From: [REDACTED] **On Behalf Of** CCD Planning Consultations
Sent: 21 September 2017 15:46
To: Planning.Responses
Cc: Derek Whittington
Subject: RE: Planning Consultation on: EG/69/17/PL

SUBJECT: EG/69/17/PL - 4 No. live/work units, Research & Development propagation building & growing area, garden room, fuel store & greenhouse to main dwelling & formation of new access.
This application is a Departure from the Development Plan.

Swallowfield, Eastergate Lane, Eastergate, West Sussex, PO20 3SJ

Heather Godmark			
Swallowfield, Eastergate Lane			
Visibility Splays and Swept Path Analysis			
Varies @ A2	SMO	ALB	PMR
October 2017	2016/3448/001		C

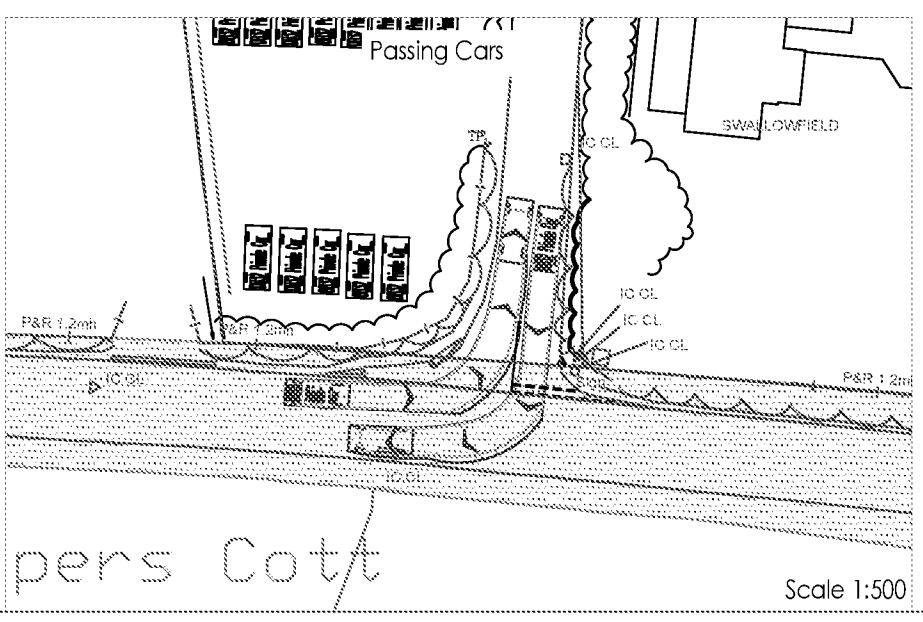
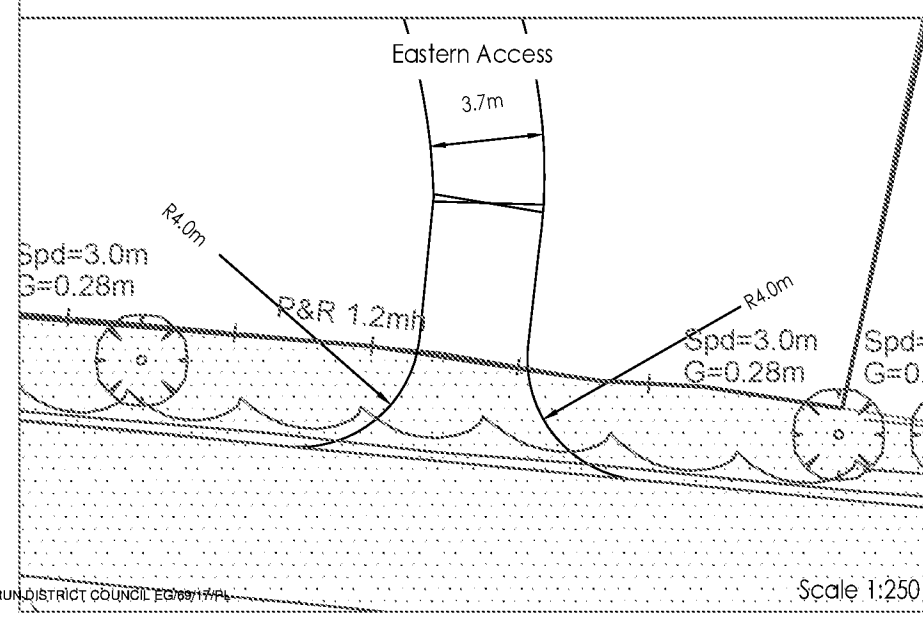
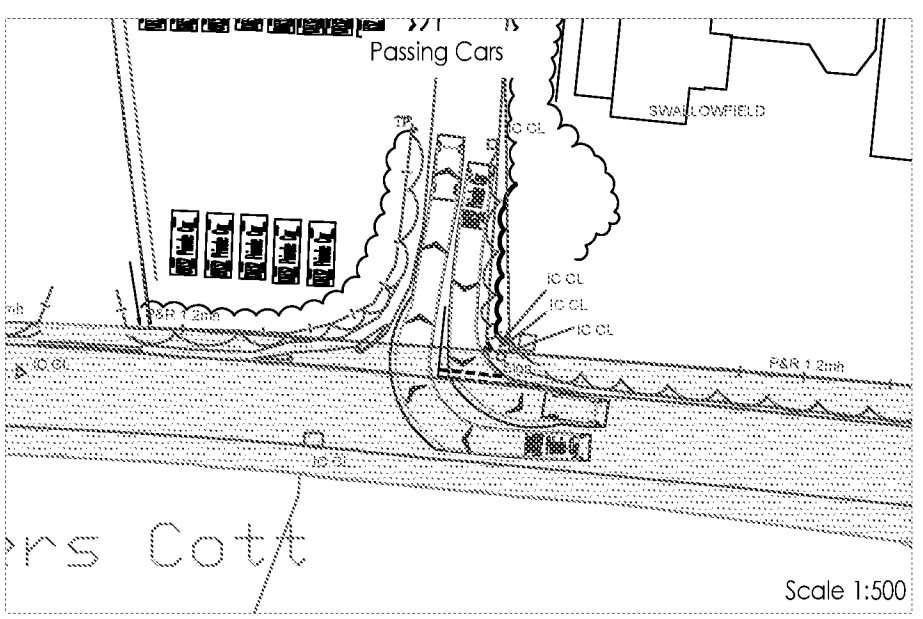
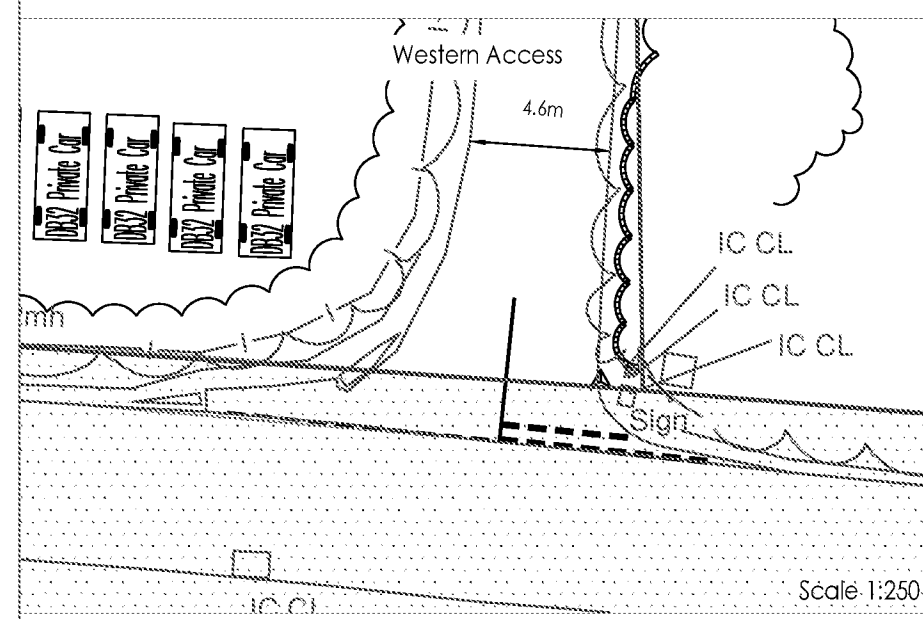
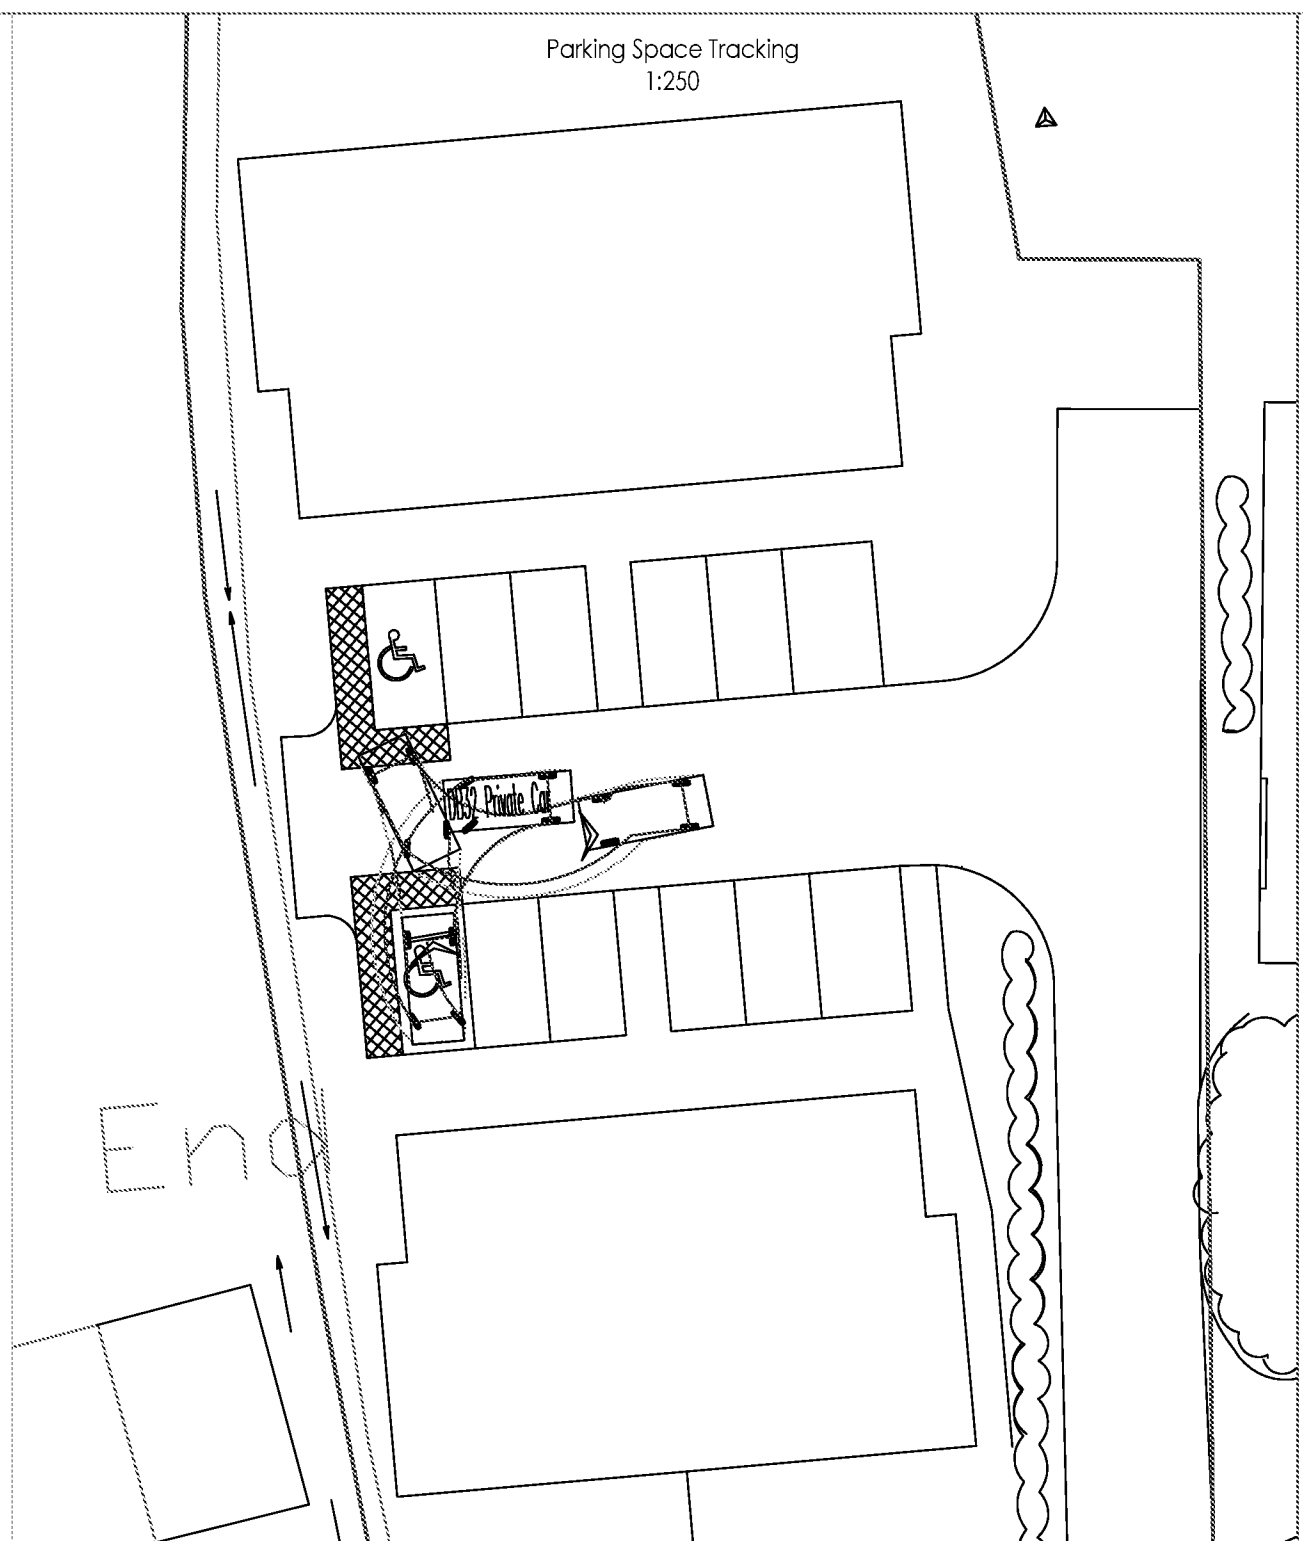
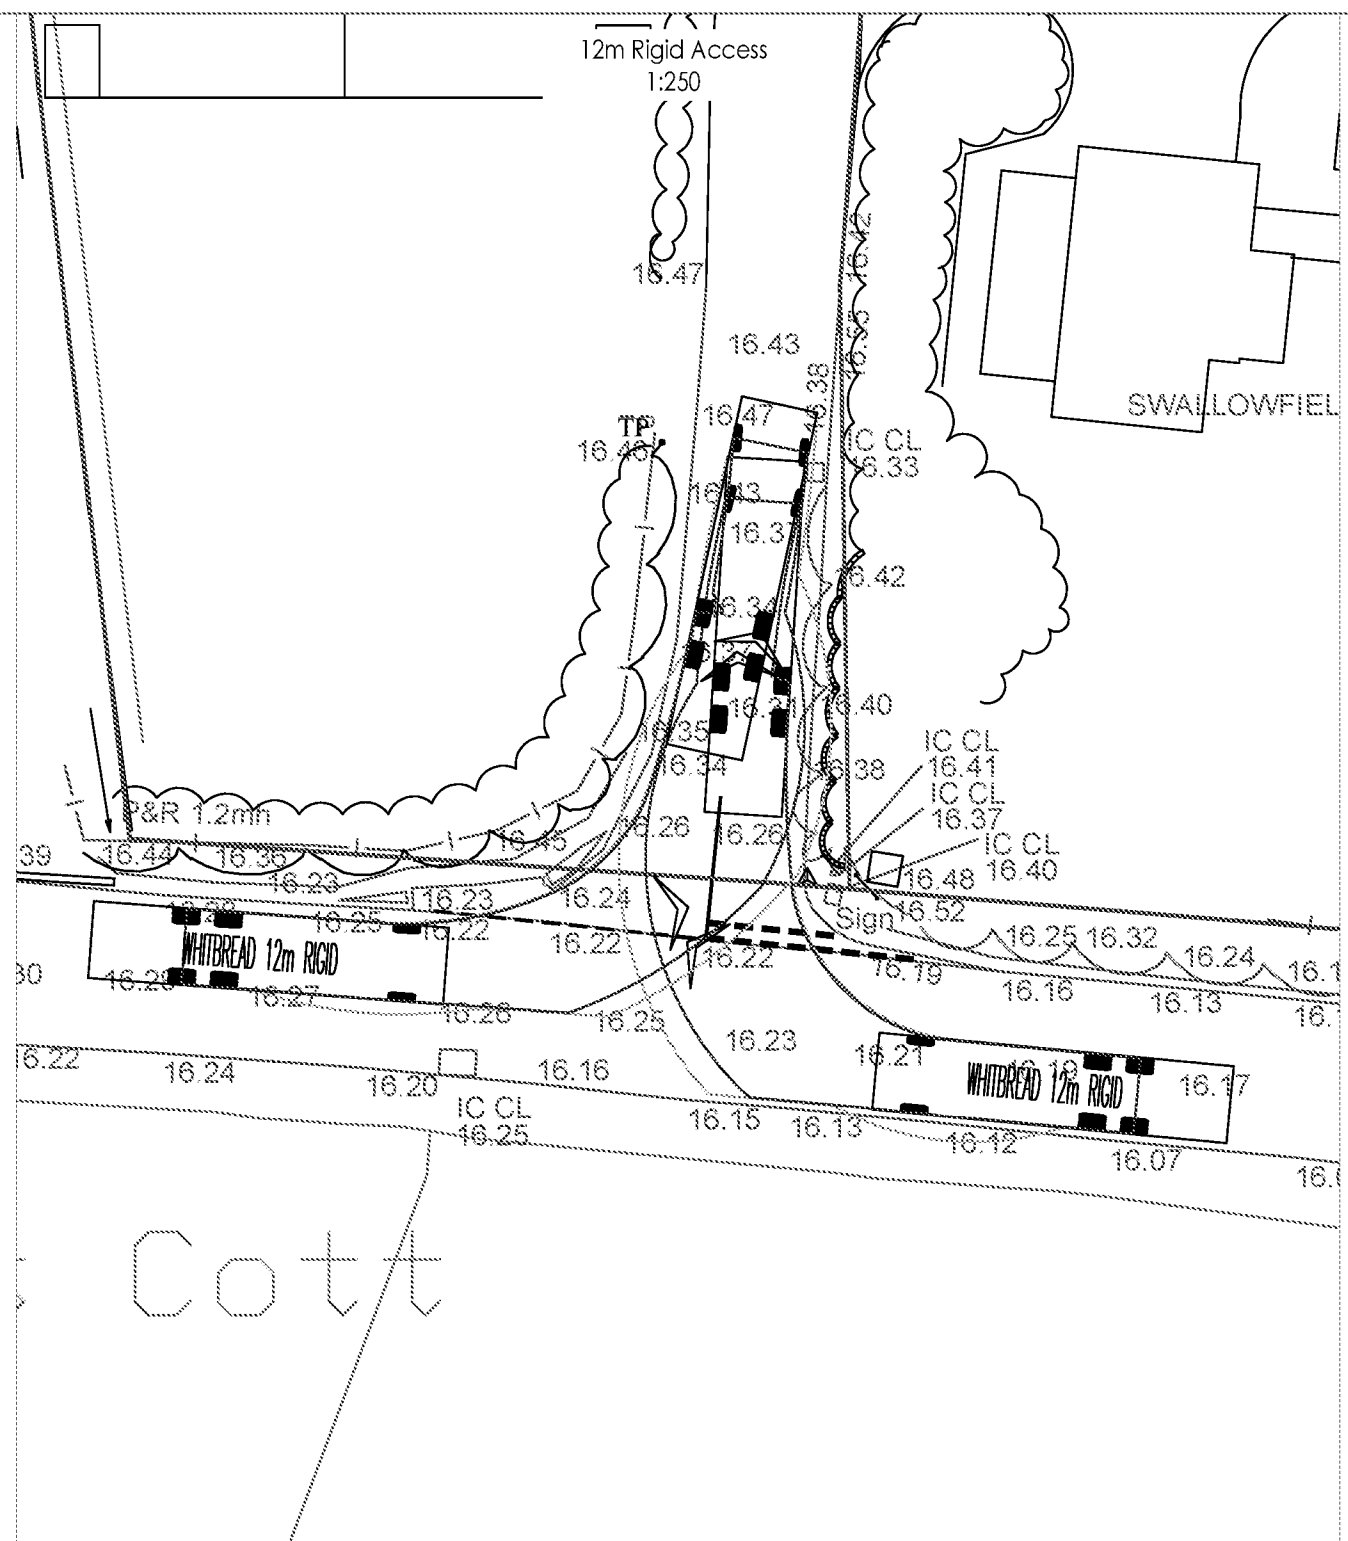
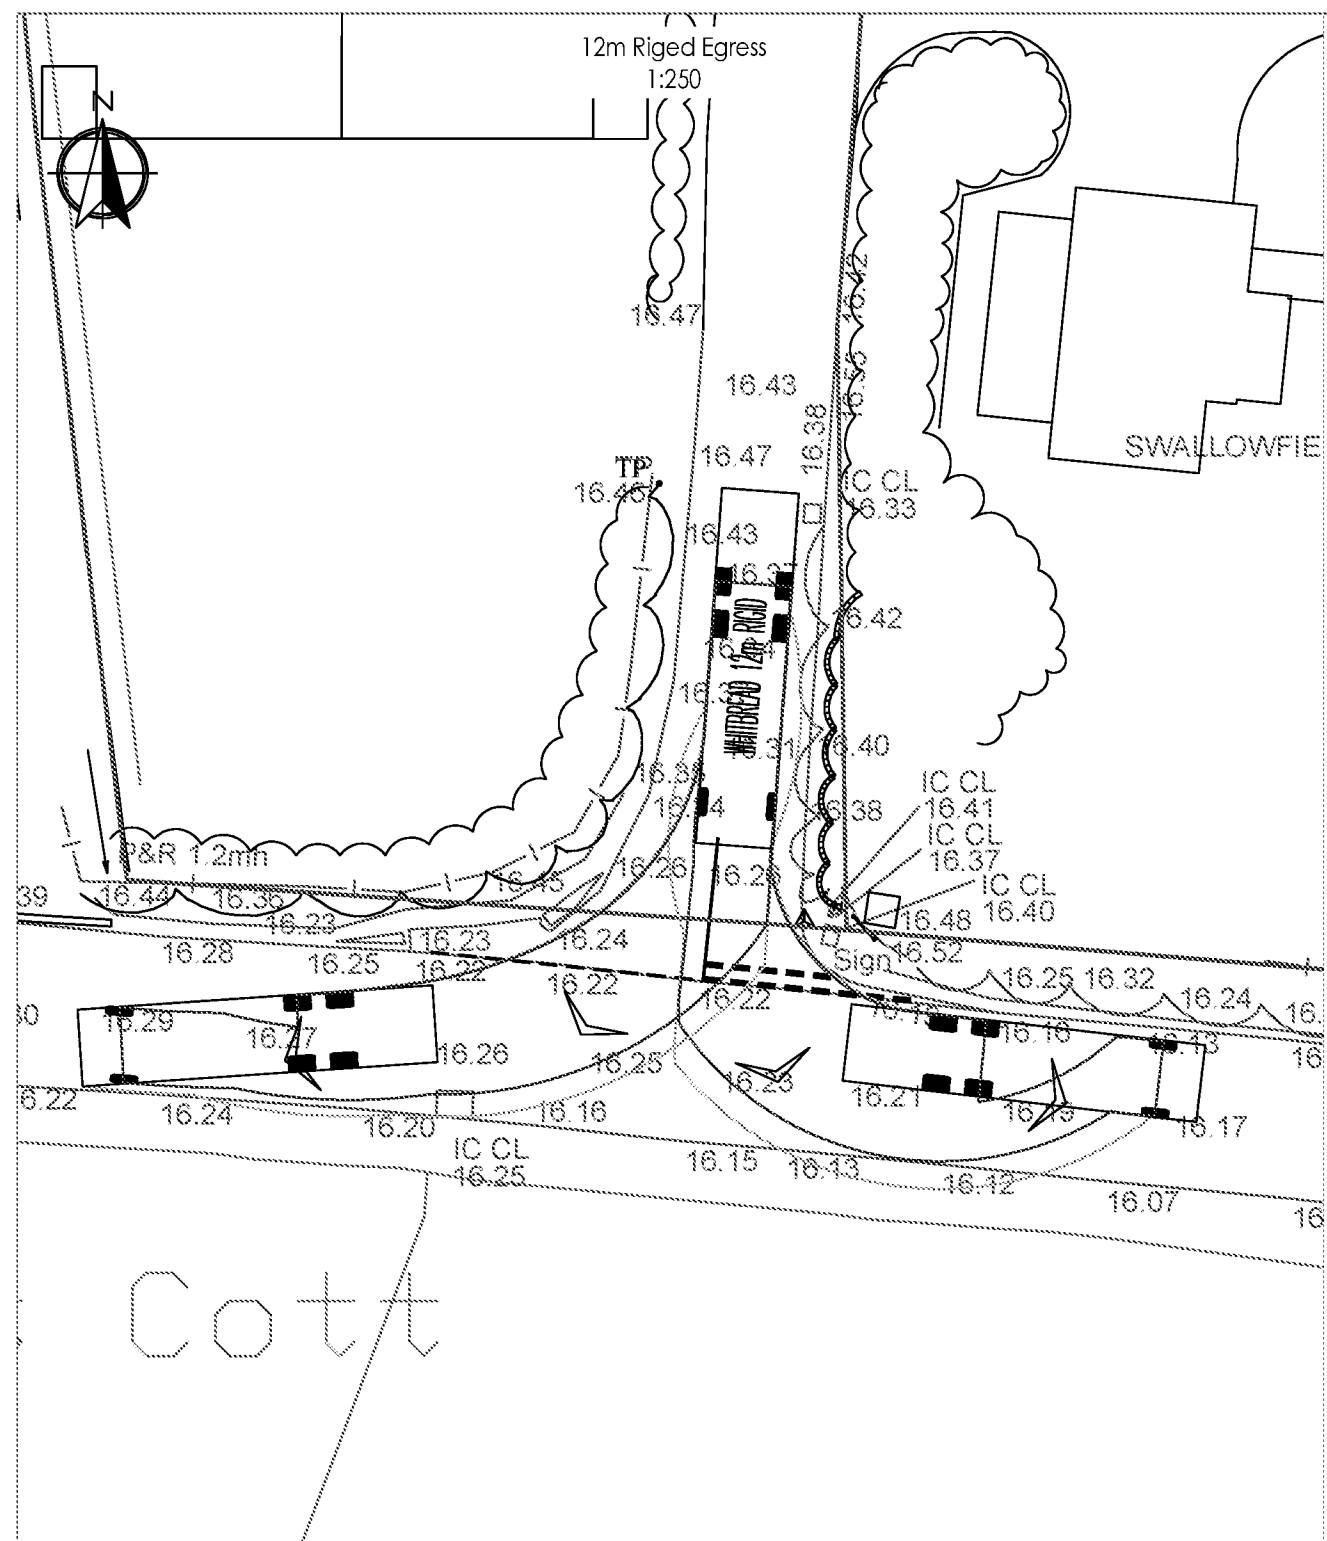
It is proposed that the existing vehicle access to the live/work units will be formalised with priority junction road markings. The existing geometry of this access will facilitate the anticipated vehicle movements and be suitable for emergency vehicles. This is demonstrated in dwg. 2016/3448/001 via swept path analysis. The applicant should provide a more detailed plan indicating the proposed road markings and a Road Safety Audit (RSA) should consider both accesses with emphasis on markings for existing access.

A new 3.7m wide bellmouth access is proposed to serve the eastern section of the site with 4m wide corner radii. It has not been demonstrated that two vehicles would be able to pass at the access or within the site. The proposed gate will be set back 7.1m however it is not clear whether this is suitable. The applicant should provide tracking diagrams and clarify whether any larger vehicles will utilise the site, which may require a set back of the gate by 10m to allow such vehicles to wait clear of the highway. The TS states that swept path tracking has also been demonstrated for the new access showing a large van accessing the site, however this is not apparent on dwg. 2016/3448/001. We note the internal access is annotated to be used by 'light' vehicles only however consideration to refuse collection vehicles and Fire Appliance should be given.

Design Manual for Roads & Bridges (DMRB) would be applied as the relevant standards considering vehicle speeds are above 40 mph. The desirable minimum for posted limit of 40 mph is 120m Stopping Sight Distance (SSD). Paragraph 3.2.5 of the TS states that 'desirable minimum' calculation set out in DMRB has been used. Paragraph 1.26 of Highway Directive TD9/93 (DMRB) states that relaxations below the desirable minimum are not permitted on the immediate approach to junctions. Nevertheless WSCC Departure from Standard (DfS1/4) allows that Manual for Streets 2 (MfS2) methodology be used for calculating SSD at accesses which meet certain criteria. In this instance the DfS would be acceptable and the LHA concur that a reduced splay of 103m to the west and 107m to the east is suitable to the recorded speeds. 106.8m has been demonstrated to the east though the LHA is satisfied that using a slight offset into the carriageway edge the full 107m would be achievable. This has been demonstrated within publically maintainable land for both the existing and proposed access. Nevertheless extensive cutting back of the hedgerow may be required to facilitate these splays. The LHA will be undertaking a site visit to confirm that the demonstrated splays are achievable and the applicant should note this advice also relies on the speed counters being taken in a suitable location.

The swept path plans do not demonstrate turning within the site for larger vehicles such as a Fire Tender and delivery vehicles. Considering the warehouse is to remain on site it is anticipated that space for turning of larger delivery vehicles is required. More detailed swept path plans should be provided for the proposed access also.

The TS states that bin collection is to be from Eastergate Lane as existing. Nevertheless, bin storage areas are shown within the plot of each dwelling and it is not clear whether these will be wheeled to the highway, which is in excess of 25m distant. If Refuse Collection vehicles are to serve the site internally then a turn at the culmination of the access drive should be demonstrated via swept path analysis.

Turning within the eastern section of the site should also be suitability demonstrated for a Fire Appliance and waste collection arrangements clarified.
